January 27, 2016

Project Name: Canal Landing New Yard
Address: 400 West Commercial St.

Project ID: #2115-101
CBL: 59-A-3-4; 60-F-1-2-3-4; 71-F-2-4-5-6

TO: Rick Knowland, Senior Planner
FROM: David Senus, P.E.
DATE: December 22, 2015
RE: Canal Landing, Final Level III Site Plan Application & Response to Comments

DRAWN: PBF DATE: APRIL 2015  
 DESIGNED: SRB SCALE: AS NOTED  
 CHECKED: SRB JOB NO. 3091.04  
 FILE NAME: 3091.04-CONCEPT GRADING  
 SHEET: C-3.1

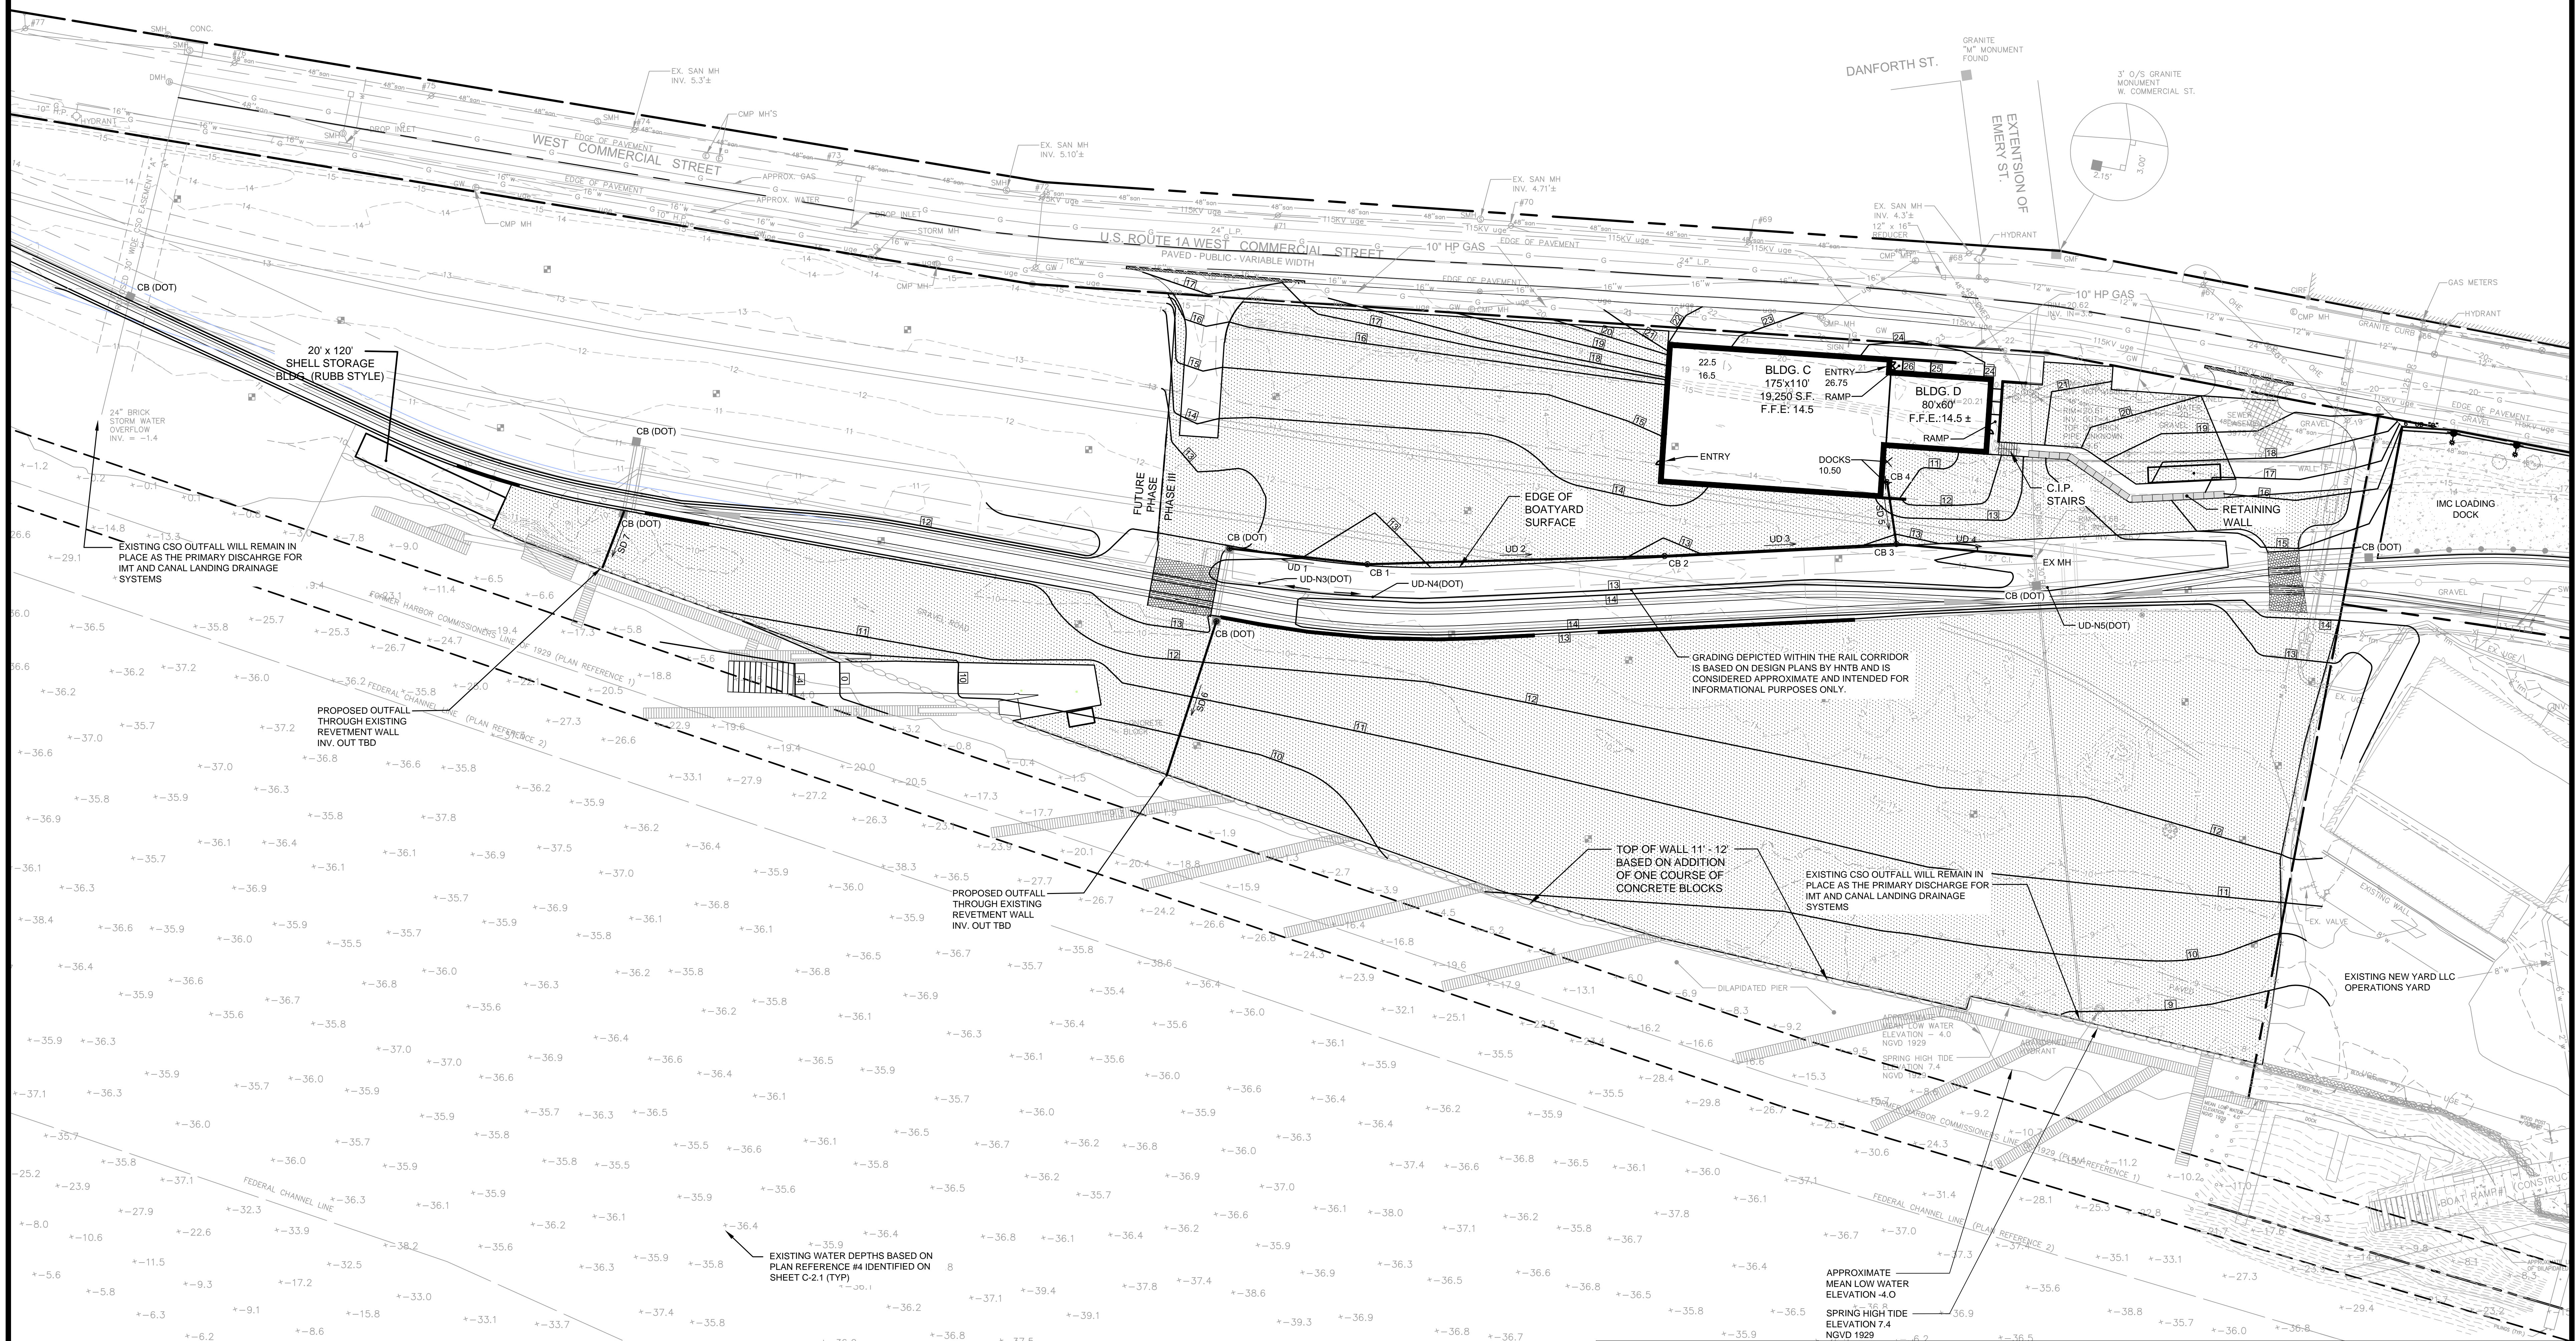
- 6) C-3.1 – Two new outfalls are proposed through the sea wall. Is outlet stabilization required at these locations (is there a soft bottom or existing stone bottom at these outfall locations?). Will this work require approval through MaineDEP & USACOE?
